Technical Memorandum

29 August 2023

To	Angus Walker	Contact No.	-
Copy to	Andrew Byrne	Email	-
From	Matthew East	Project No.	12578580
Project Name	DFDS Traffic Impact Study - Immingham		
Subject	IERRT – DFDS Written Response Addendum – Annual Throughput and Terminal Capacity

I:\uk\p02\Maritime\PROJECTS\Ports\VT\B2429400-ABP-Project\Sugar\1100-Design-Engineering\1102-Drawings\01-Preliminary\02-DCO Drawings\B2429400-JAC-00-ZZ-DR-ZZ-0206 - P02.dwg - 08/02/2023 10:38:03 - 0206 - HodgeT

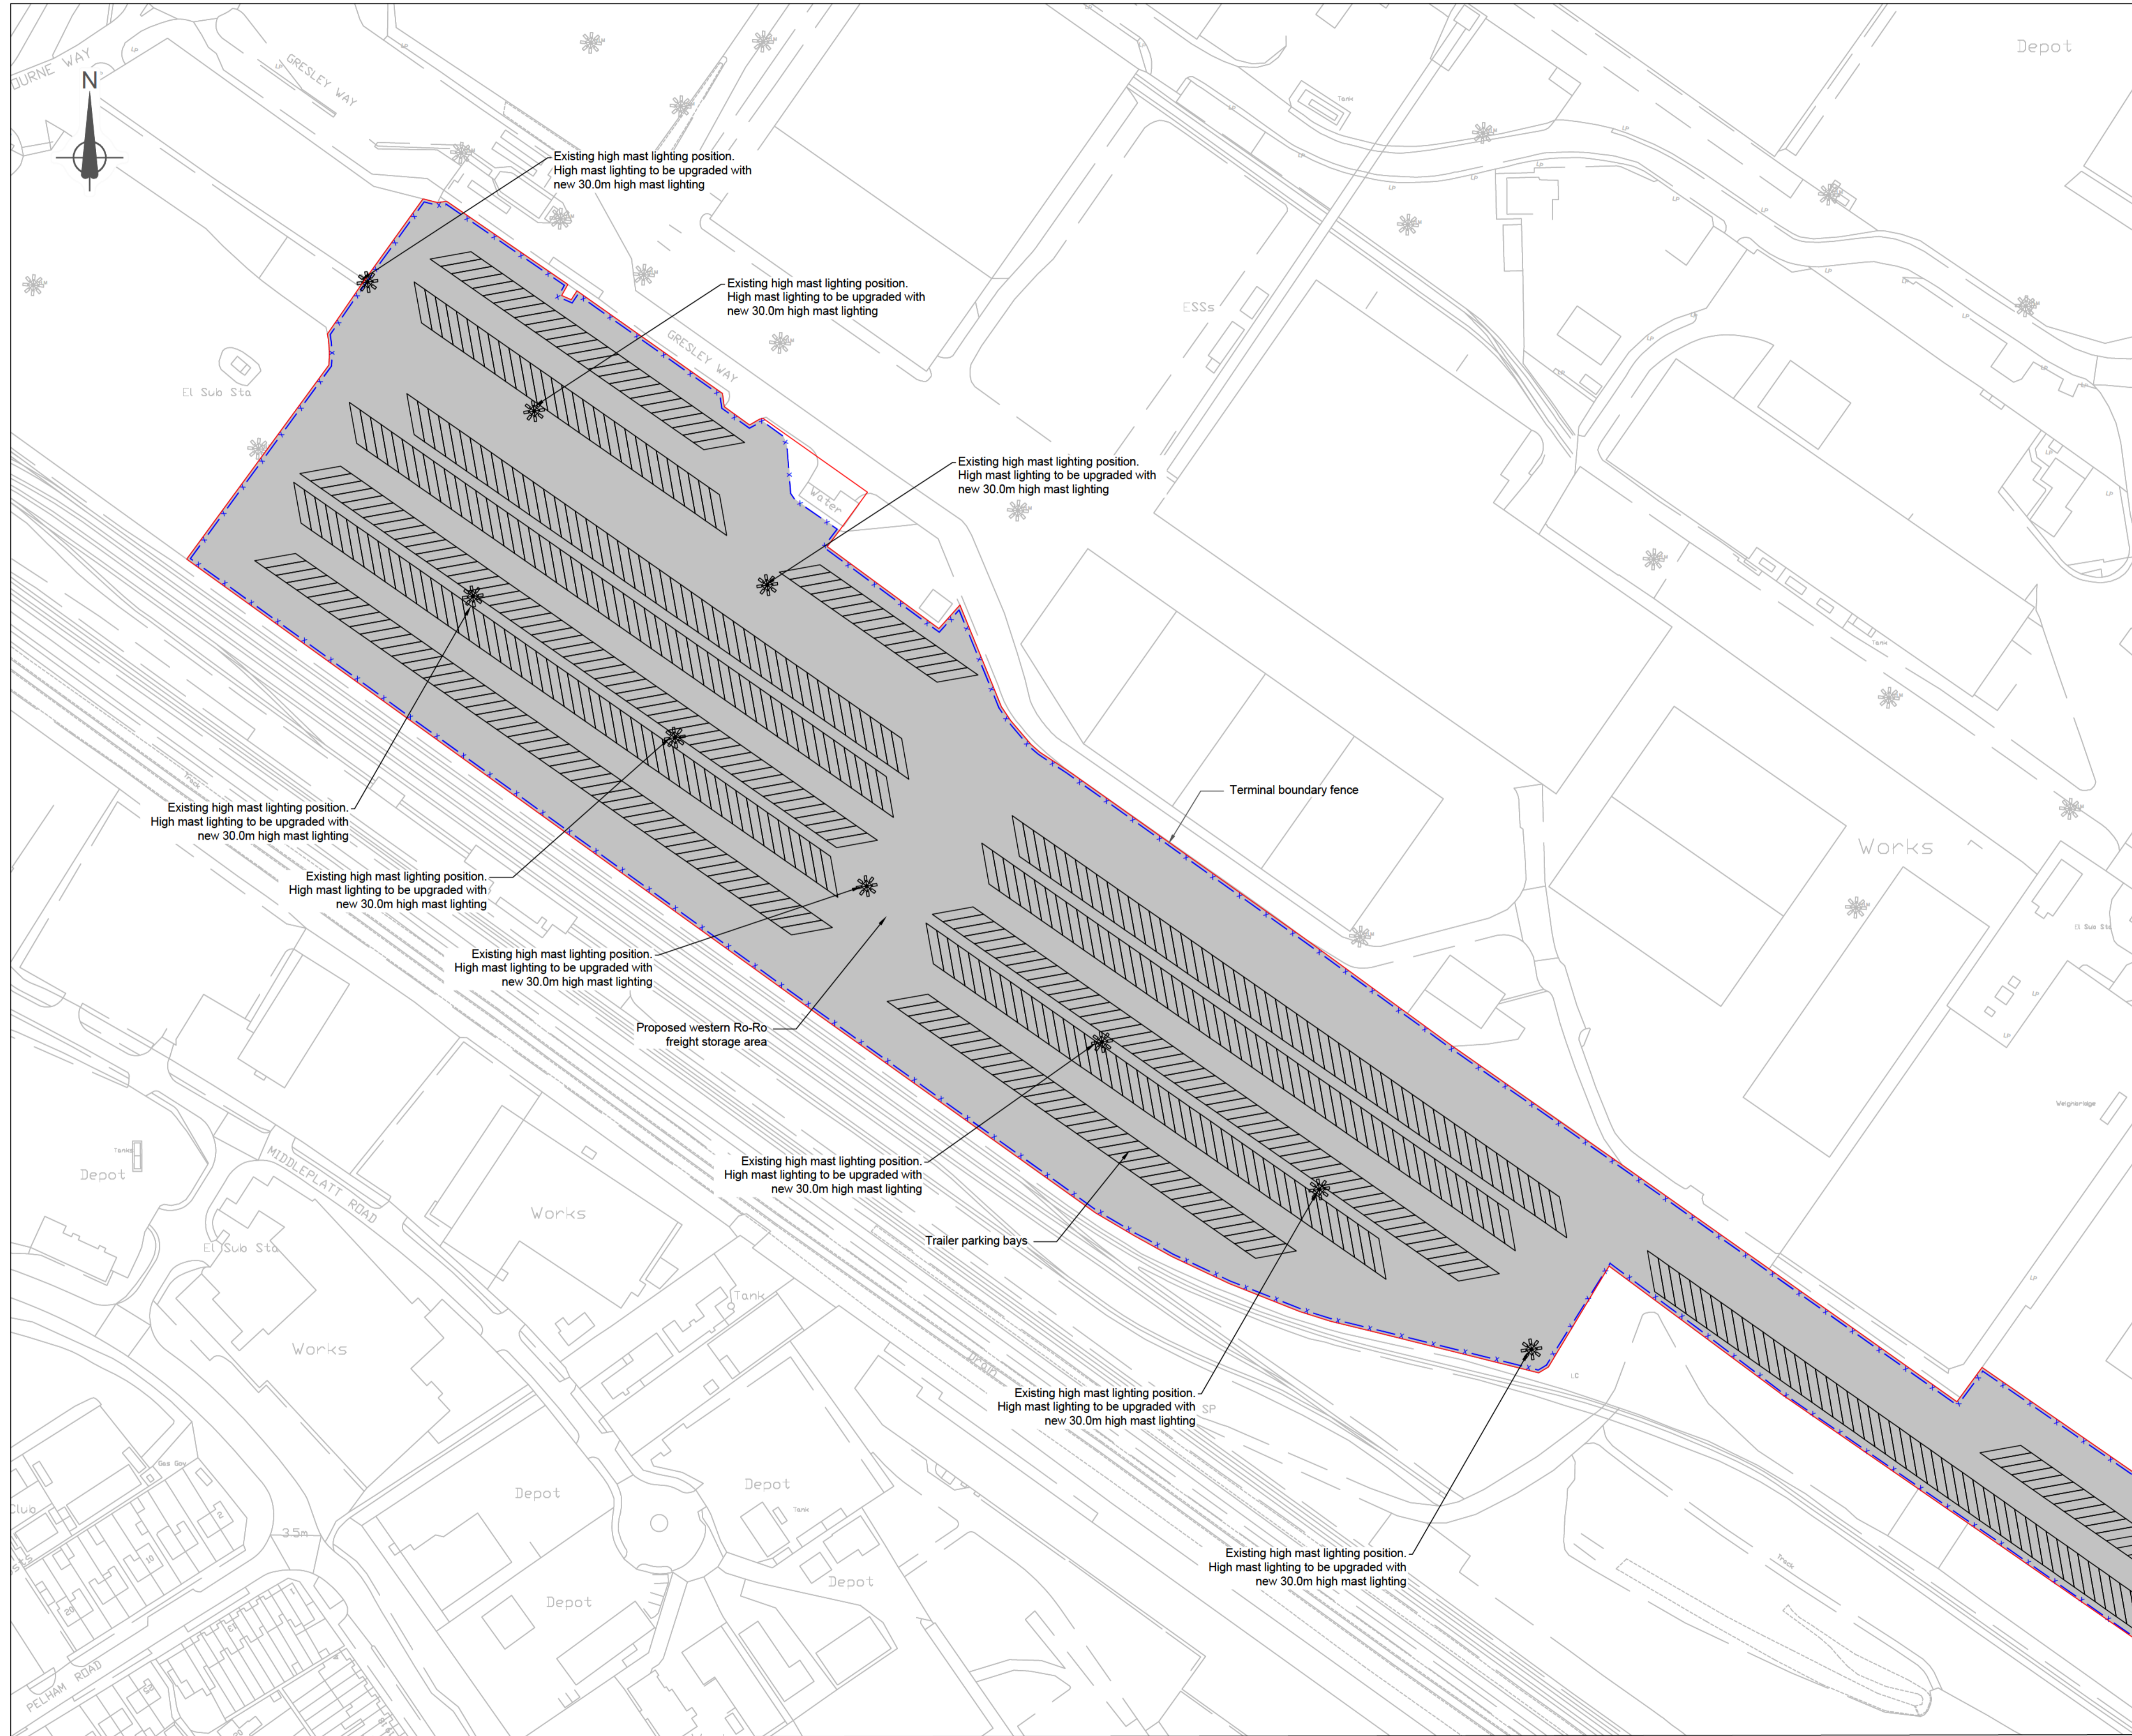
The intended configuration of the IERRT terminal is described within the Engineering Sections Drawings and Plans¹¹. These drawings identify:

- The location, stack height and number of slots for containers (slots are described in twenty foot equivalent units (TEU));
- The number of bays for trailer parking;
- Swimlanes for accompanied unit parking prior to boarding vessels; and
- Waiting areas external to the terminals security gates which are within the terminals boundary.

GHD have reviewed these drawings and identified the following approximate figures (note, as the files are only provided in pdf format, counting and measuring has had to be completed manually potentially leading to minor discrepancies in values presented).

Area	Lane Meters (m)	Container Slots (TEU)	Trailer Spaces (Units)
Northern	0	38	239
Central	0	0	157
Southern	1,420	0	355
Western	0	0	635
Total	1,420	38	1,386

Assuming a provision of 18 metres for each accompanied unit, and a stack height of three (3) containers per slot (as shown in the Engineering Drawings), the current terminal provides static capacity for:

- 79 spaces for waiting export accompanied units within the terminal, and a further 78 waiting spaces outside of the terminals gates (it is assumed imported accompanied units will not reside at the terminal, therefore spaces would only be utilised for exports);
- 114 TEU's (containers) for imports and exports; and
- 1,386 spaces for unaccompanied trailers for imports and exports.

Using the identified terminal configuration and operating assumptions, and assuming that on a peak day that all spaces are utilised within the terminal, the terminal configuration only has sufficient capacity if the dwell rate of unaccompanied and containerised is an average of around 2 days.

However, under the circumstance that all unaccompanied and containerised spaces are utilised, there is likely to be operational challenges generating congestion at the terminal gatehouse, which will in turn create delays for vehicles entering the terminal, leading to queuing back onto the port road network.

Further, for the terminal to handle 252 accompanied units to be loaded onto the departing vessel, the swimlanes provided to would need to be replenished in excess of 3 times (i.e. once per vessel). This would mean that the applicant would need to ensure that boarding of the vessels is completed against a controlled schedule. This is also operationally complex and has a high potential of resulting in congestion and queuing on the port road network.

Based on operational parameters identified and carrying over the average dwell rate of 2.1 whilst factoring in the estimated peaking factor based on DFDS operations of 122%, the terminal is estimated to have an annual capacity of just under 300,000 RoRo units per year¹⁸. In a simplified view, this is determined by the following equation:

This is substantially less than the quoted maximum of 660,000 units per year. This supports the applicants consultant view that the terminal acts as a physical control on the annual throughput and the maximum volume in the dDCO would not be achievable.
